Application No: Y/53/22/DOC
Registered: 29th April 2022
Site Address: Land at Stakers Farm North End Road Yapton
Description of Works: Approval of details reserved by condition imposed under Y/44/17/OUT relating to condition 17-as built drawings of implemented scheme.

Following your comments on my email the other day, please find below the response for: Y_53_22_DOC

The construction does not appear to have been carried out in accordance with the design, in addition there are still elements of the construction which are wholly reliant on the contractor's information rather than an independent verifier. As a result, **we would not recommend Discharge of Conditions** until the following information has been provided and following points have been addressed and approved in full.

Notes:

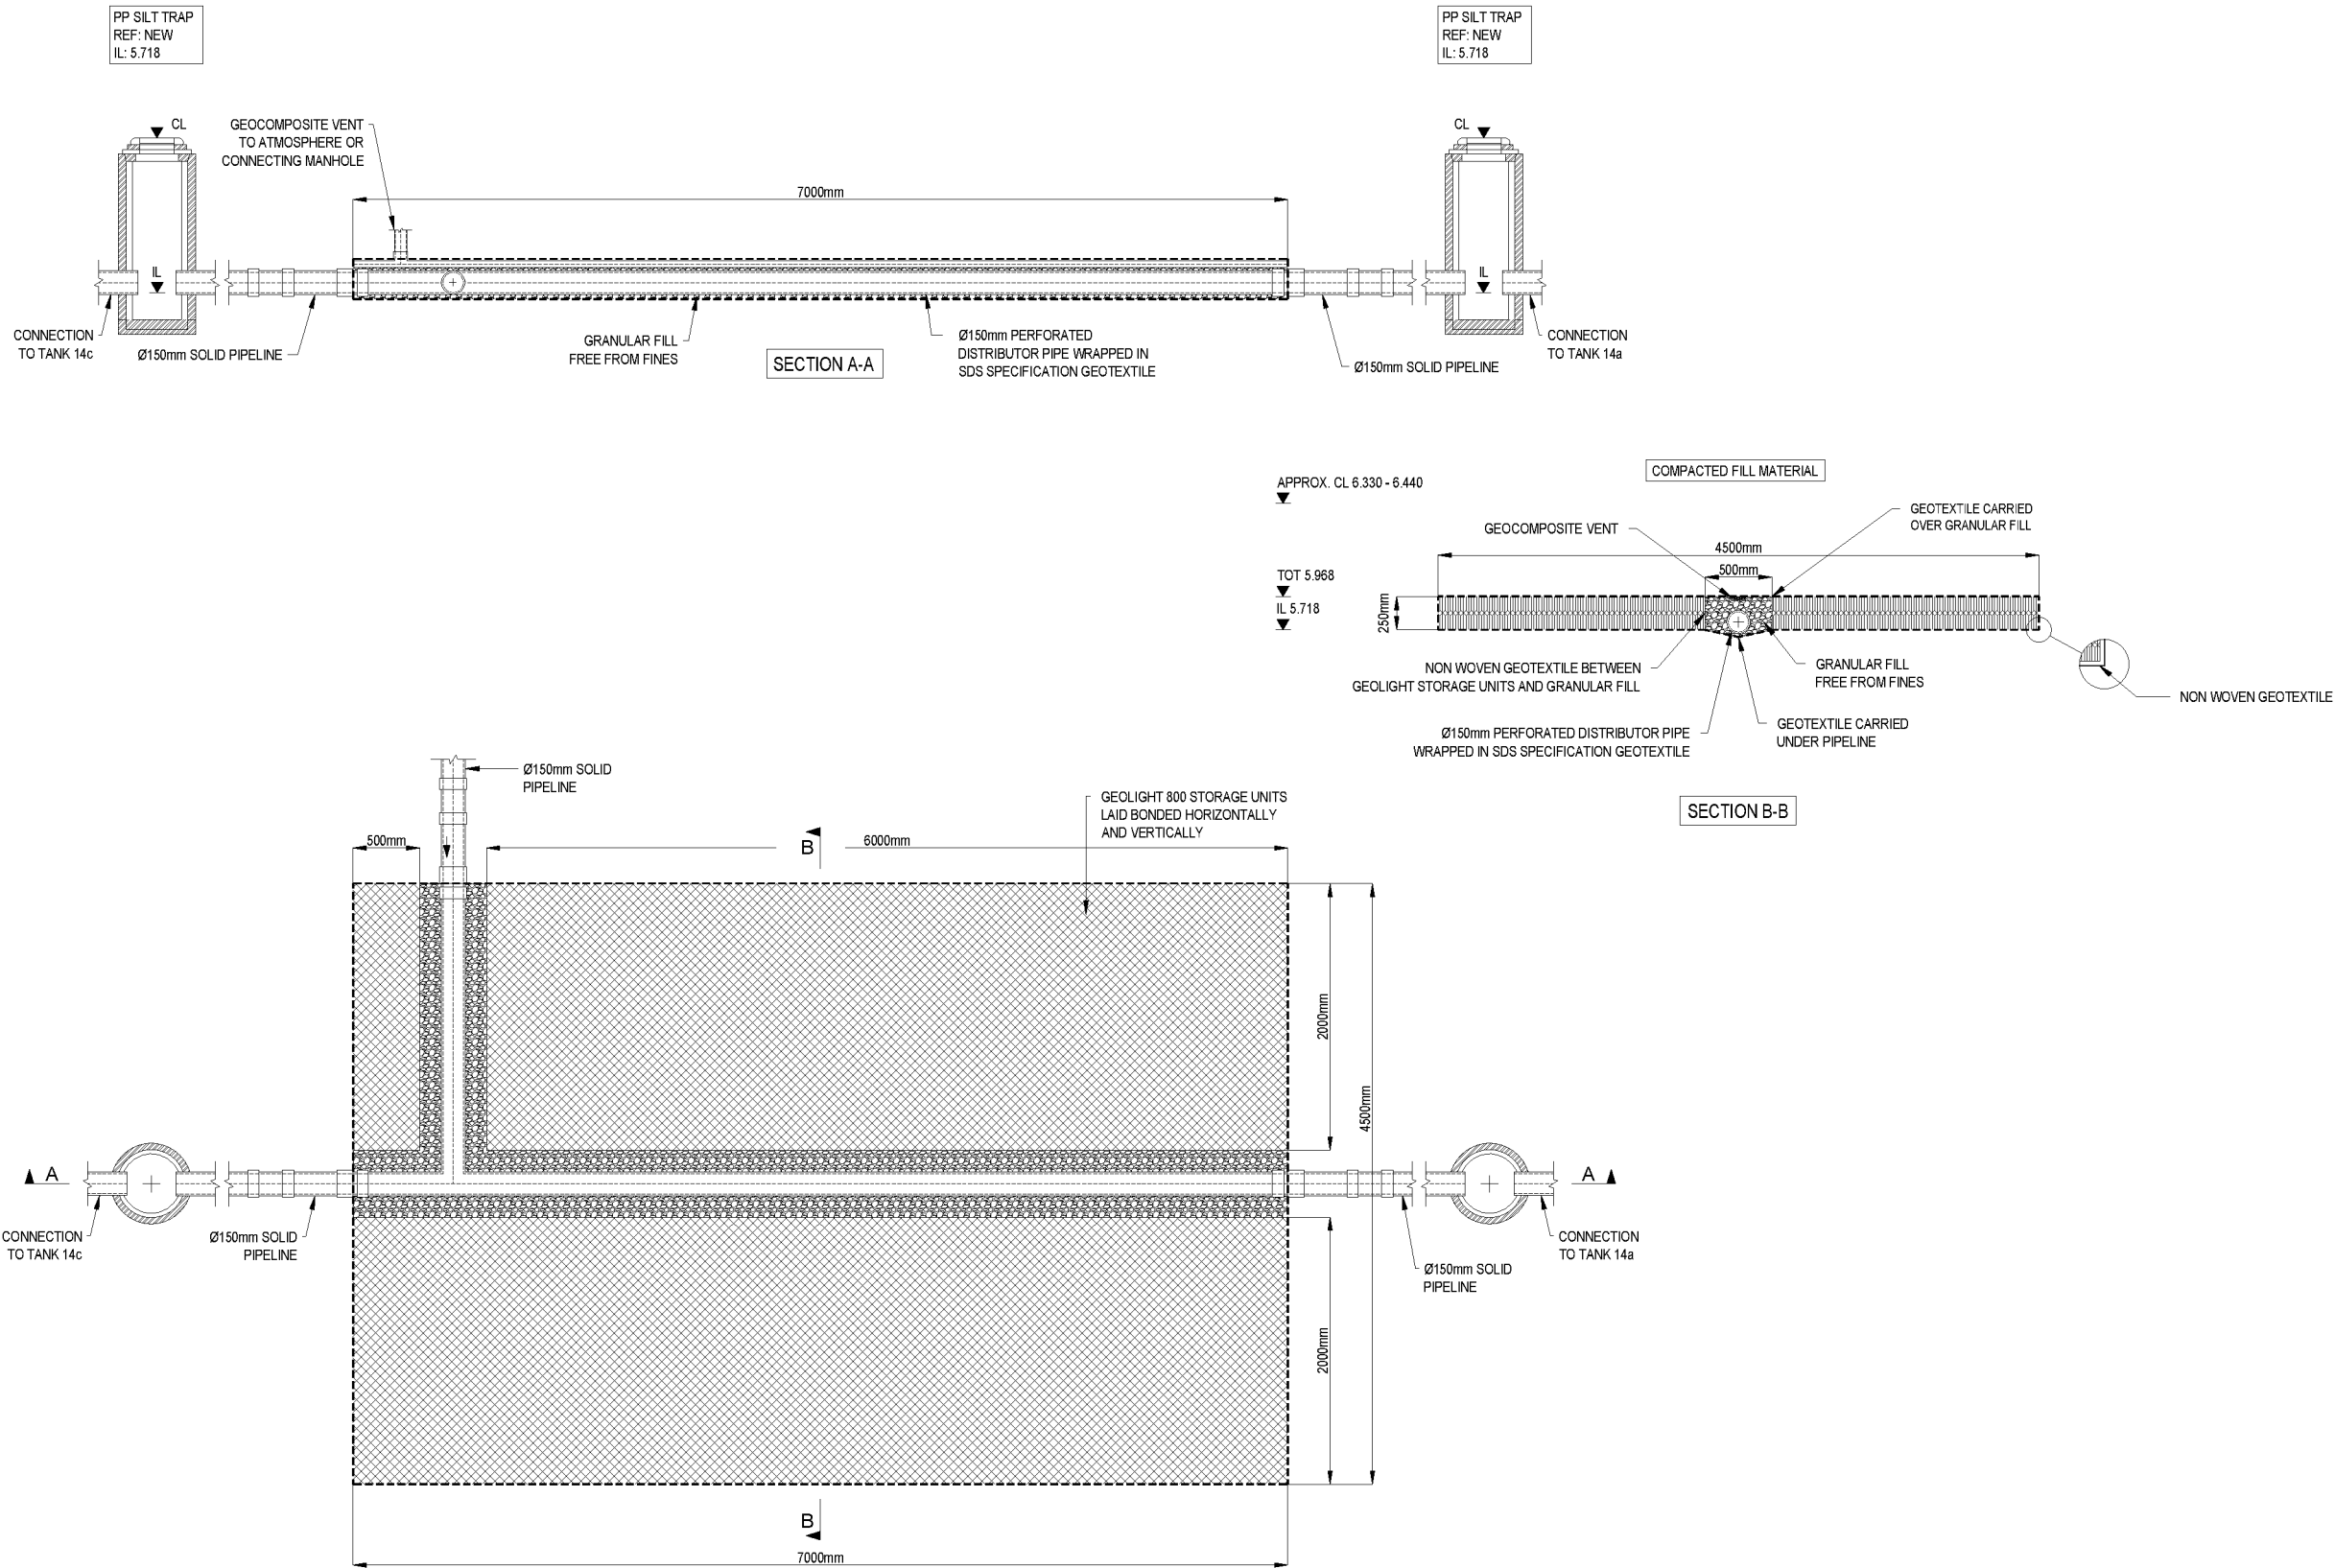
- Checking and remediation of the poorly constructed sediment traps (assuming they are installed as photographed). The sediment traps should be installed as per the submitted drawings. These photographs show several defects in construction including square cut outs used to house round pipes, cracked rims and

plastic, the use of unapproved materials within their construction, rubble filling the base (which visually cannot be confirmed to have been lined) and concrete which appears to have been used as a sealant and is partially blocking one pipe outlet. None of this appears on any of the approved drawings.

- A proposal for remediating these issues should be submitted.
- 4) The letter submitted detailing all of the drawings refers to YAP-180-31 REV C4 however, the submitted planning drawing is Revision C5. The applicant will need to confirm which drawing the contractor was working off and confirm that the scheme was not constructed to an earlier design.
- 5) We also acknowledge significant differences in the levels for the base of the permeable surfacing, and appreciate the revised calculations showing that this will only result in minor flooding in one area of the site. This is noted to occur but is not significant enough to warrant remediation as the volumes are small and flooding only occurs infrequently (based on the model results).
